Please find attached PDF pack of all plans, with an updated block plan (drawing no. 1485-01) which includes dimensions from the proposed extension to relevant boundaries, as requested.

Cc: Richard Conroy [REDACTED]
Subject: RE: Request for further information A/66/21/HH

DRAWING NO	DATE	DRAWING	PROJECT
1485-01	25.02.21	SITE LOCATION AND BLOCK PLAN	16 PINE TREES CLOSE ANGMERING LITTLEHAMPTON BN16 4LT
DRAWN	SCALE		
RC	AS SHOWN @ A1

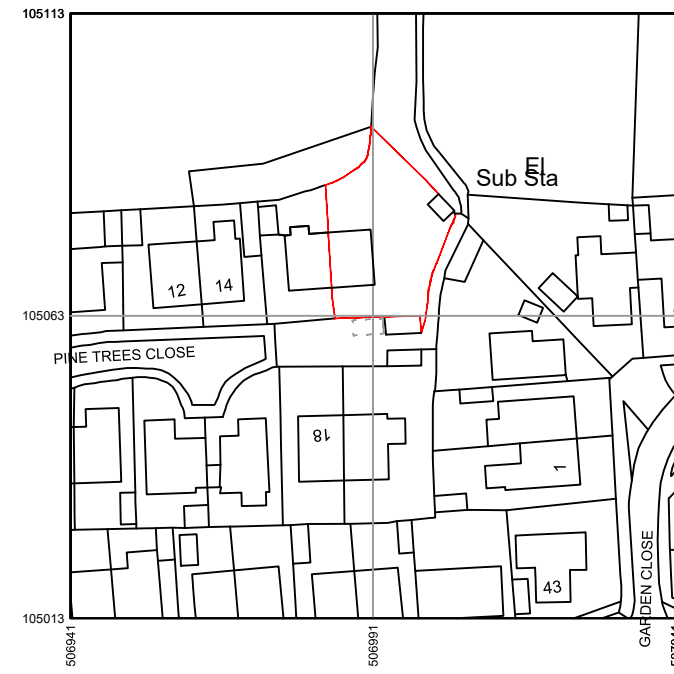
Thank you for providing the CIL Form. However, this application is still invalid as the block plan requires dimensions from the proposed extension(s) to all relevant site boundaries. Please amend.
